Our Ref: EG/14/15/HH

25th February 2015

Application for Householder Planning Permission

Development Two storey side extension
Location 33 Elm Grove Barnham

Location Plan

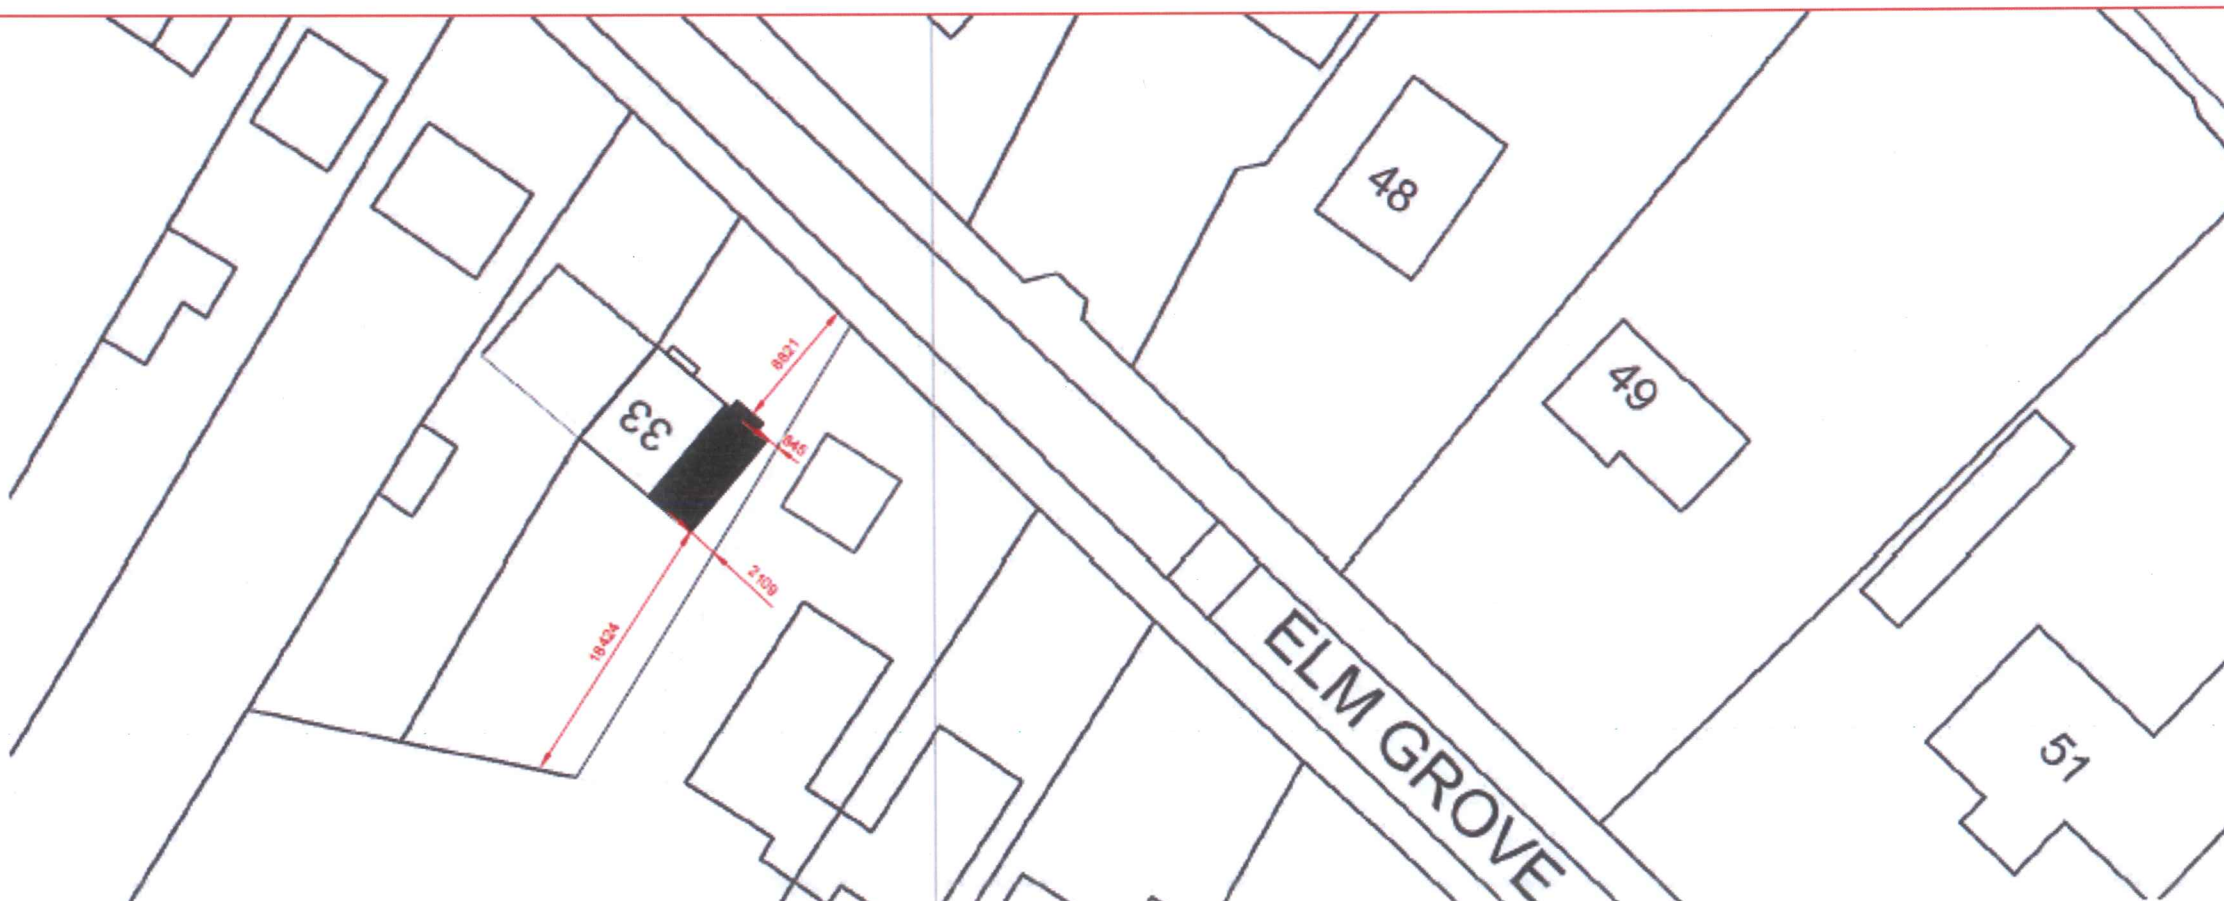
Location Plan

Please submit 1 electronic or 3 paper copies of a location plan at a scale of 1:1250 or 1:2500 for rural areas. Further details of what must be included on the plan can be found in the National Validation Requirements. Please provide another named road.

Block Plan

Please submit 1 electronic or 3 paper copies of a block/site plan at a scale of 1:500 or 1:200. Further details of what must be included on the plan can be found in the National Validation Requirements. Please provide measurements from the proposal to the site boundaries.
